Request for Clarification of Information

Address: 126 Sherwood Street

Permit #: 2016-02738

Date: 1/5/2017

Paul Jones 126 Sherwood 04103

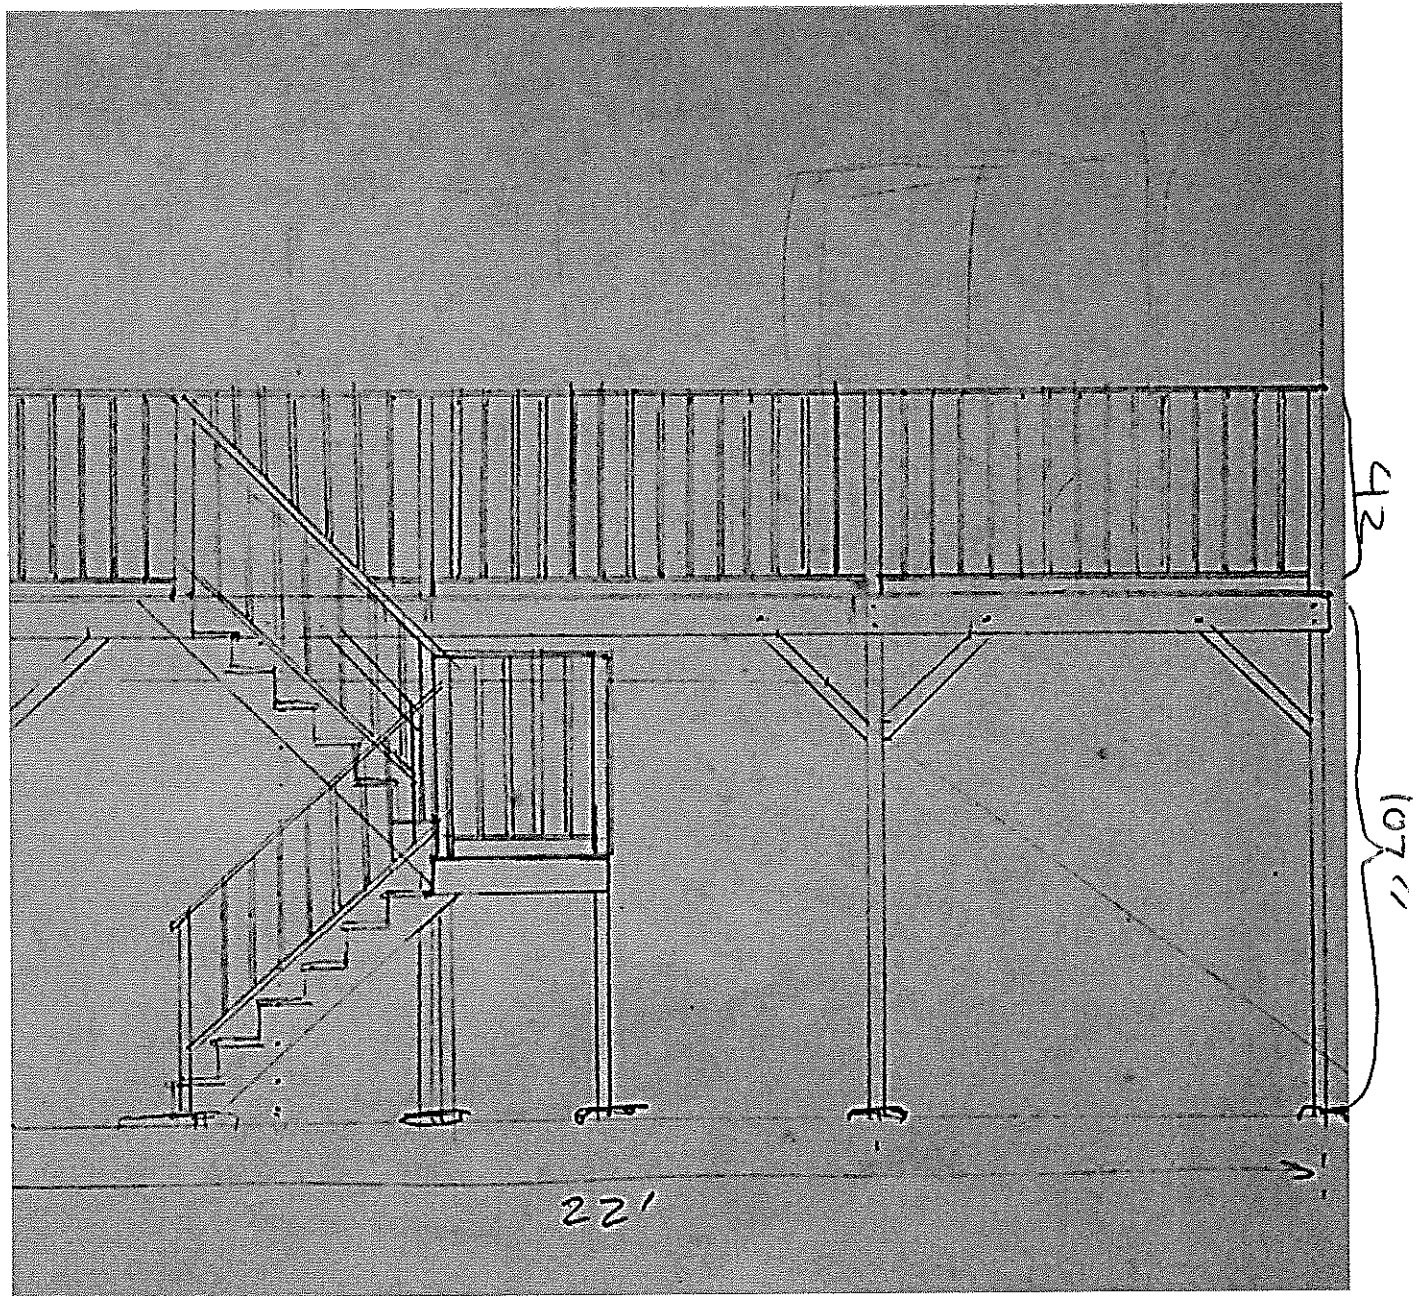
4. (page 2) Provide callout for method of anchoring Posts to "Sono tube" as called out on page 3
5. (page 3) Provide call outs for sizes and types of each lumber member

6. (page 3) Call out spacing between support posts
7. (page 3) Provide diameter for "Sono Tube"
8. (page 3) provide the height of the landing
9. (page 5) provide framing plan for Deck

TOP VIEW

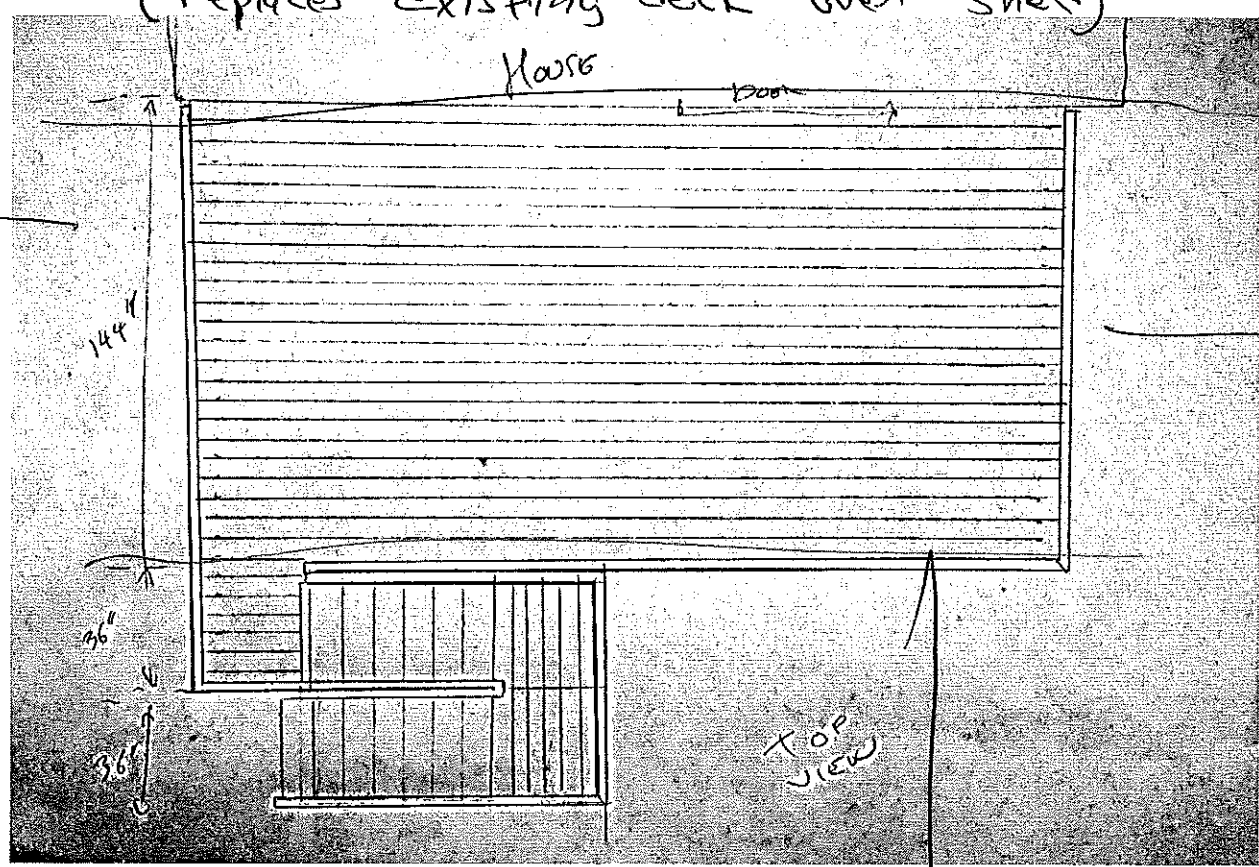
10. (page 5) Provide detail showing whether the Deck will be self-supported or supported by the existing house? (if supported by the house, inspectors must be able to the connection from the inside of the house)

11. (Page 5) Show any other beams required for the support of the deck
12. (Page 5) Show cross bracing / lateral Support as required between deck joists

13. (page 5) Will shed be removed / relocated during construction / Demolition
